23 Middle St.

Building Addition

ARI Insurance Agency

**To:** Kandi Talbot, Planner  
**From:** Anthony Lombardo, P.E., Project Engineer  
**Date:** November 16, 1998  
**Subject:** 23-25 Middle Street.....Proposed Building Rehab...

SITE PLAN
Office Building
25-27 Middle Street
Portland, Maine

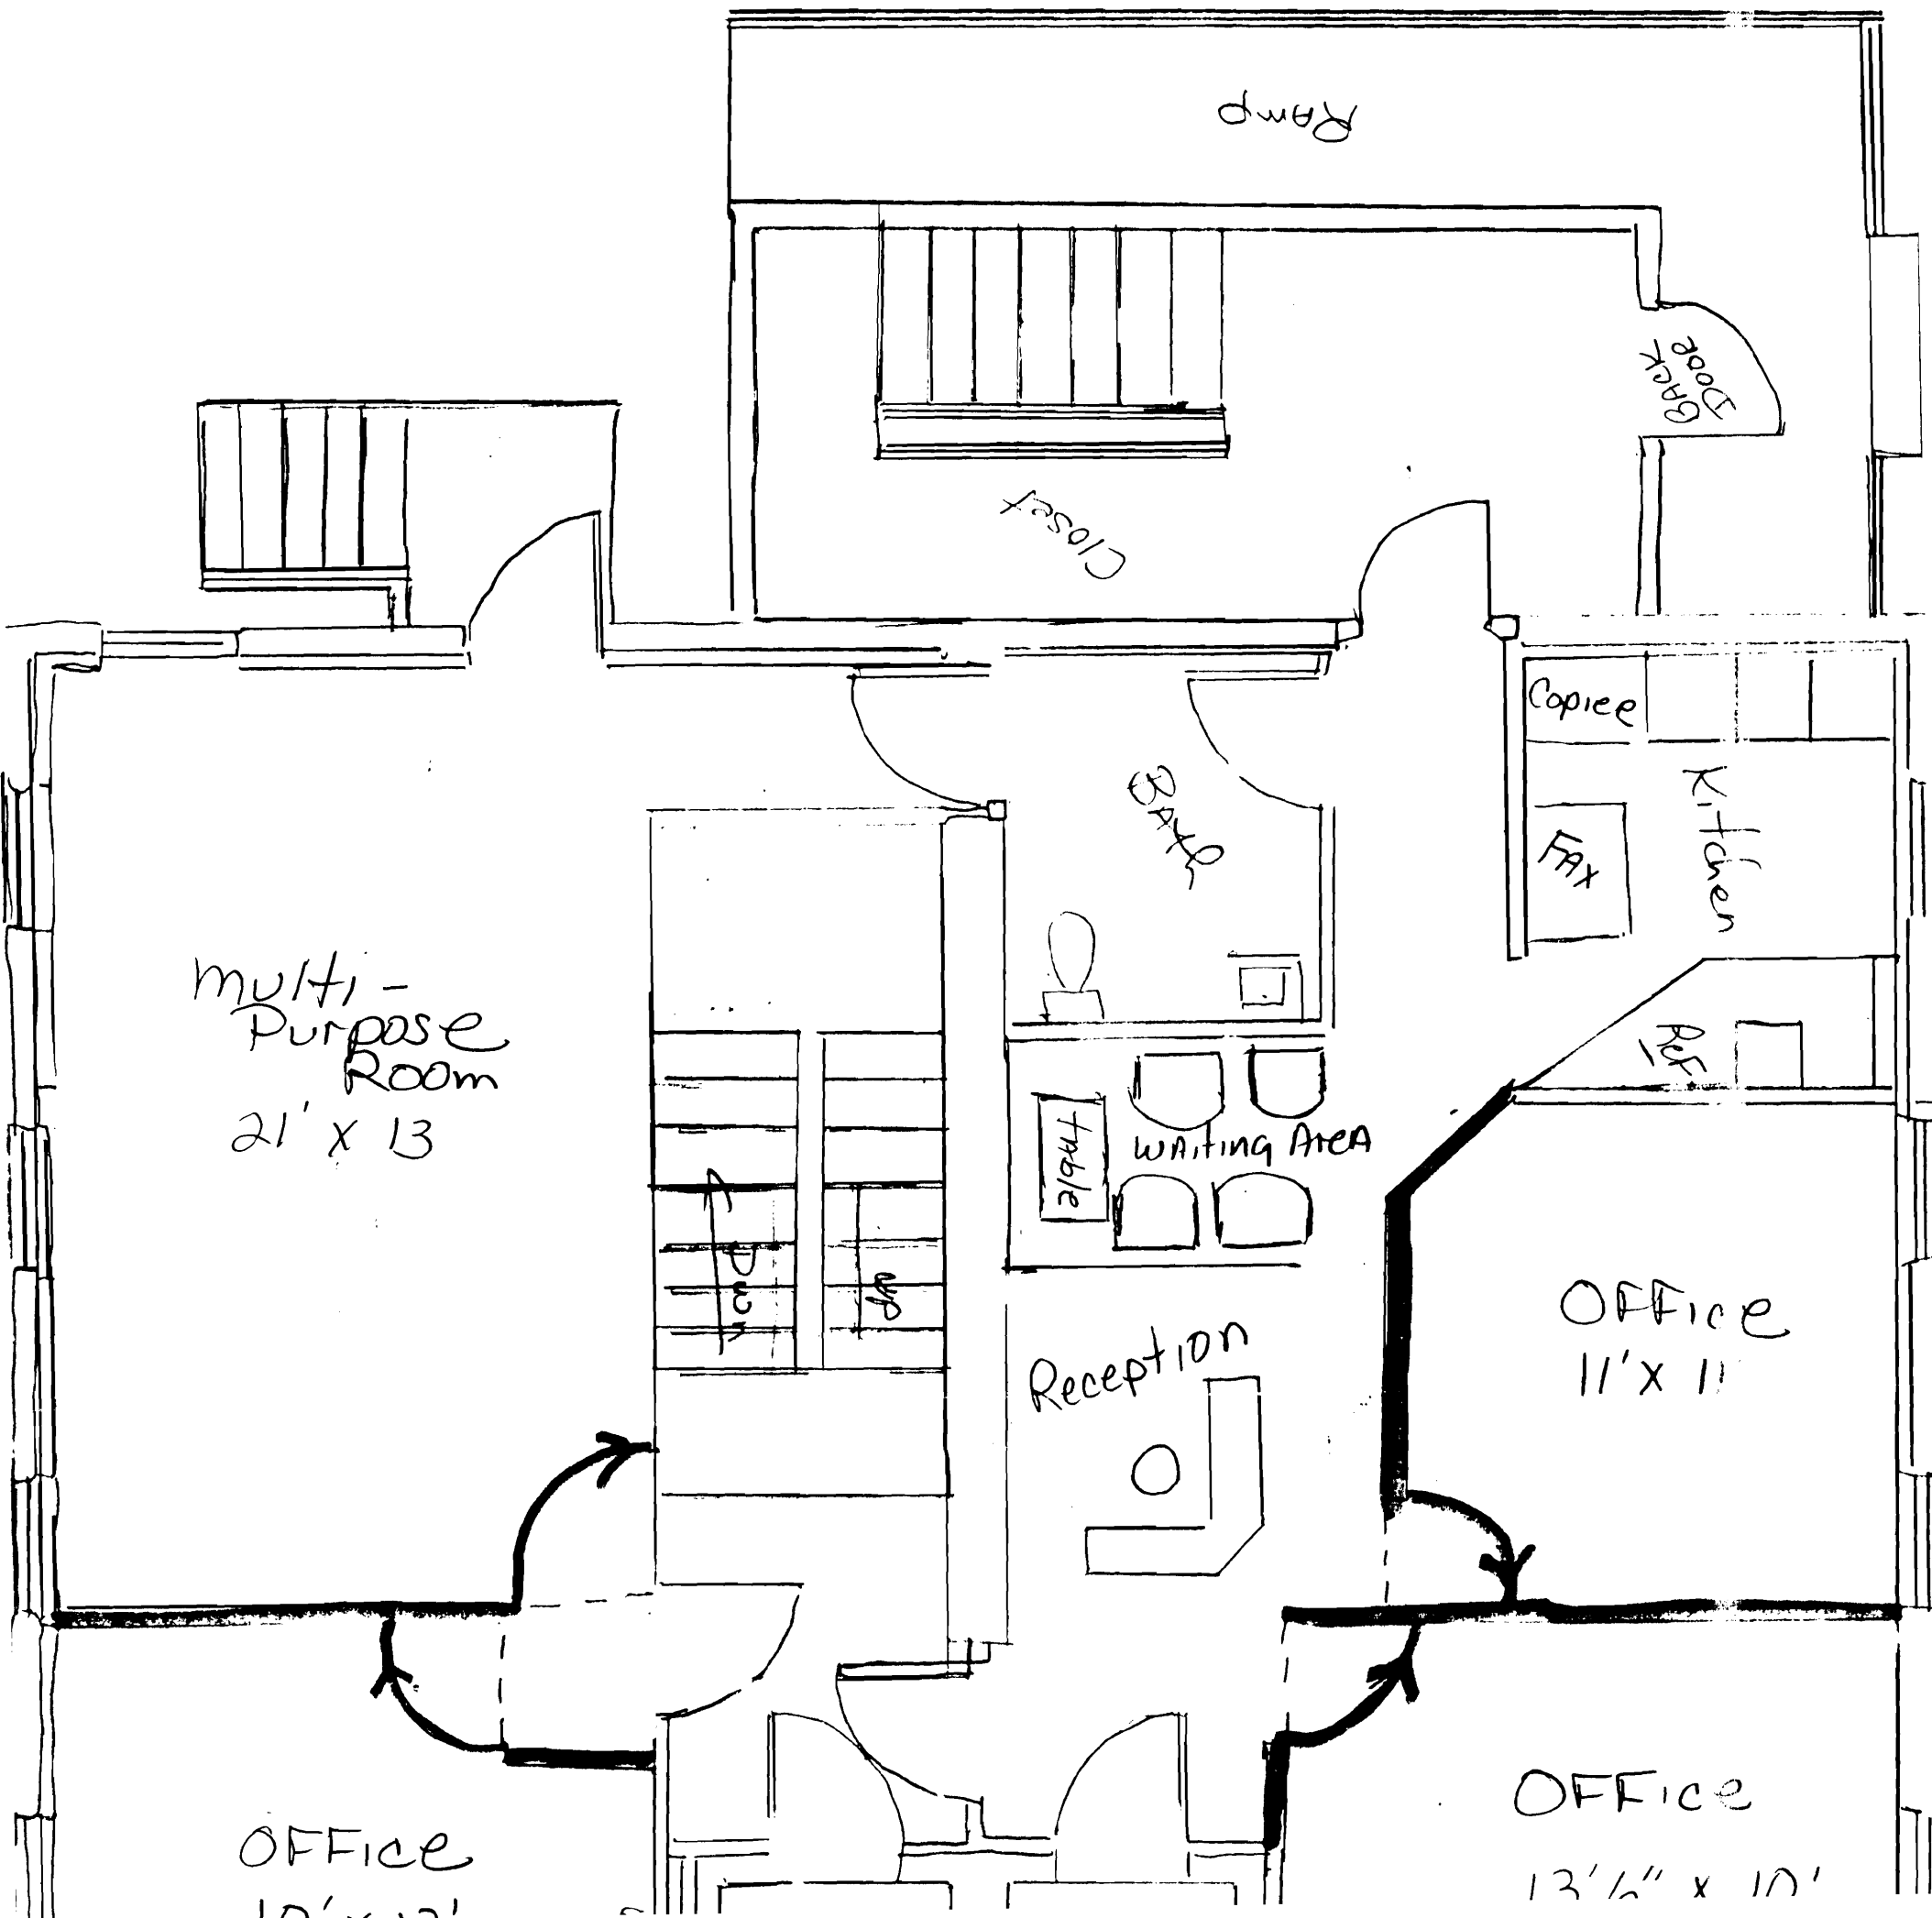
*According to the Land Use Ordinance, Chap.14-525, section (b), the applicant must submit a Site Plan which includes a "Standard Boundary Survey" prepared by a registered land surveyor, topographical information, existing utility location, etc. The boundary information submitted for review is based on the City's assessor map.*

*The applicant must include on the Site Plan all existing features and all proposed improvements. Public Works is requesting the applicant rebuild the sidewalk along the frontage of this site on Middle Street. In addition, we are requesting the resetting of granite curb where necessary, as determined by Public Works.*

- that the applicant rebuild the sidewalk along the frontage of this site on Middle Street. In addition, granite curb should be reset where necessary, as determined by Public Works.
- that street trees be planted along Middle Street.
- that the dumpster be enclosed with a stockade fence.
